**Consultation Response from KC,  
Ecology Unit**

**2021/91975 Croft House Surgery, 1145, Manchester Road, Slaithwaite, Huddersfield, HD7 5JY**

**Redevelopment of Croft House Surgery with demolition of existing 2 storey flat roof car port / office building, alterations to existing building to form 5 residential units and erection of 3 dwellings. (within a Conservation Area)**

**Date Responded:  
09/11/2021**

Proposed Ground Floor Site Plan 1:100

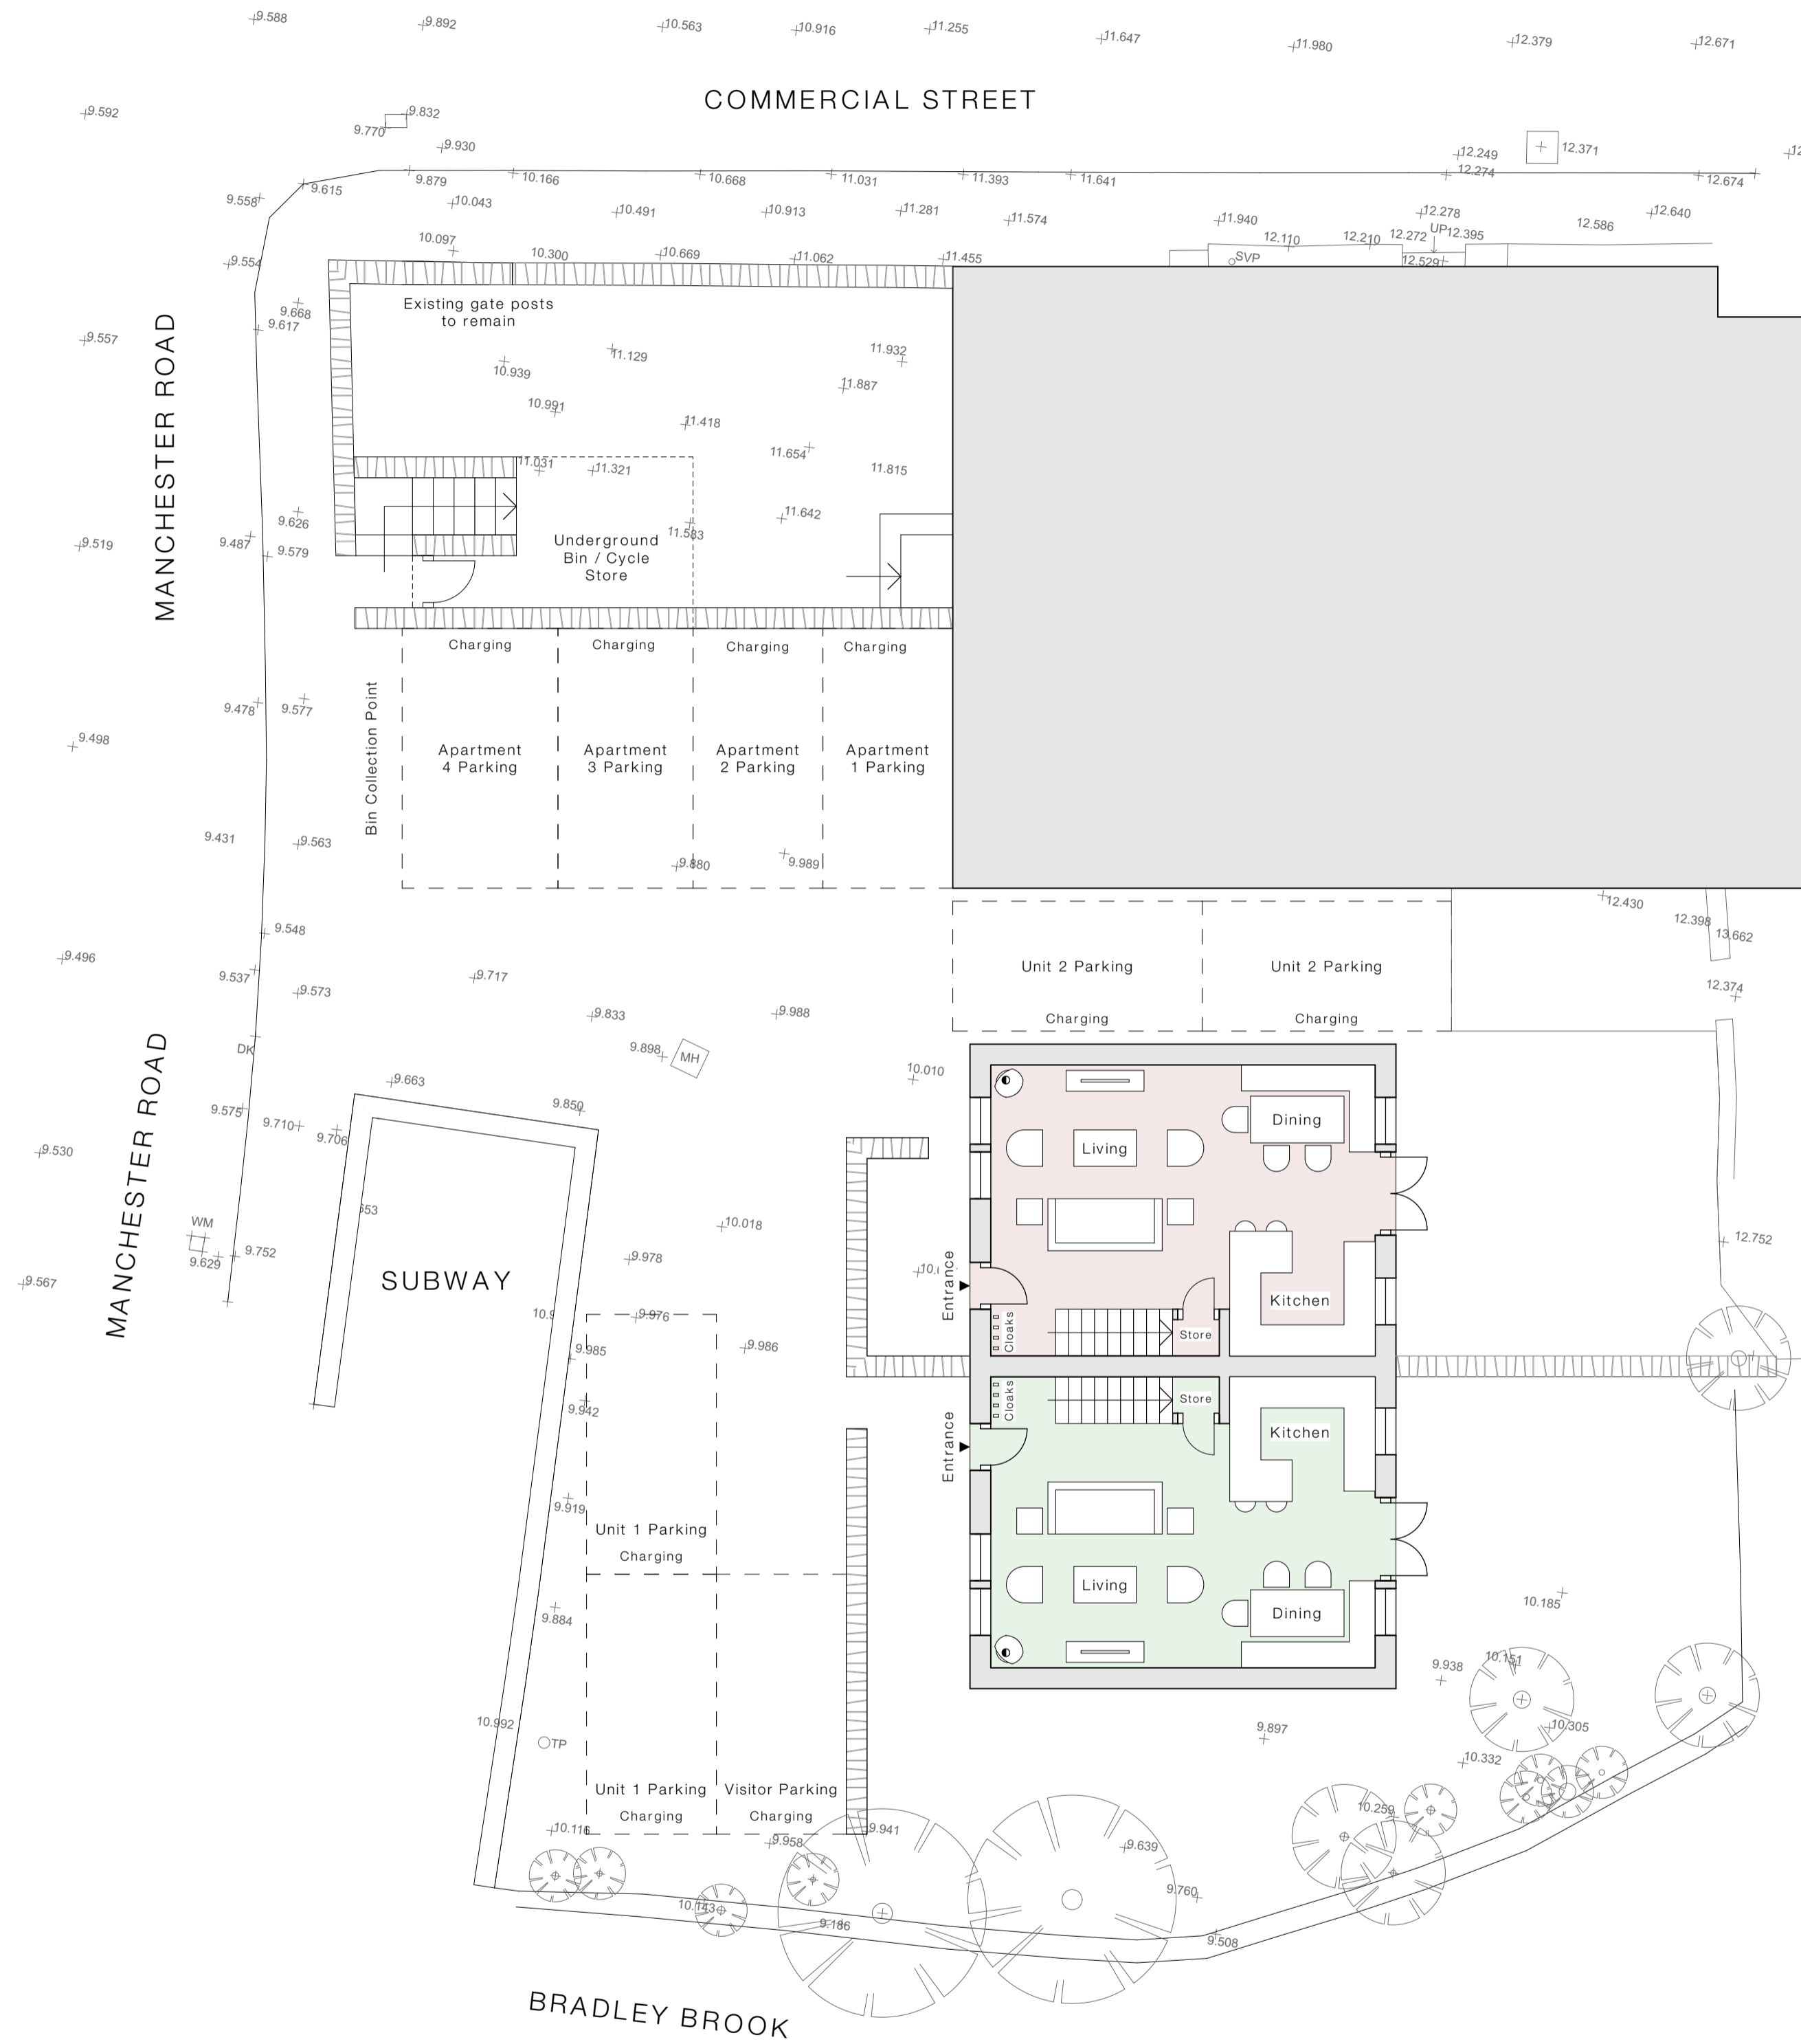
The trees and shrubs along the western boundary (adjacent to Bradley Brook) however, offer a suitable feature to be utilised by foraging and commuting bats and buffer the brook from the adjacent residential development and therefore their removal may have detrimental impacts on ecological connectivity. It is recognised that a single heavy standard tree is proposed to mitigate for the loss of T2, however this is not considered adequate to safeguard and enhance the KWHN, or to provide a biodiversity net gain post-development in accordance with Local Plan Policy LP30.

Therefore, a condition for an Ecological Design Strategy (EDS) should be applied to secure ecological enhancement including native soft landscaping, faunal boxes integrated into the new dwellings and sensitive lighting. See below for an appropriate condition-

1. No development shall take place until an ecological design strategy (EDS) addressing mitigation and enhancement has been submitted to and approved in writing by the local planning authority.

- a. Purpose and conservation objectives for the proposed ecological works.
- b. Location (shown on appropriate scale plans) of specific make and model, or design, of habitat boxes, such as bat boxes, bird boxes and hedgehog refuges. Habitat boxes to be integral to new structures where appropriate.
- c. Details of how the design of boundary treatments will not obstruct the movement of hedgehogs.
- d. Planting schedule and planting plan showing the inclusion of native species of tree and shrub to be included within/at the boundary of the application area, and how this achieves the stated purpose.
- e. Details of maintenance.
- f. Details of how and where external lighting will be installed so that it can be clearly demonstrated that areas to be lit will not negatively impact the Kirklees Wildlife Habitat Network.
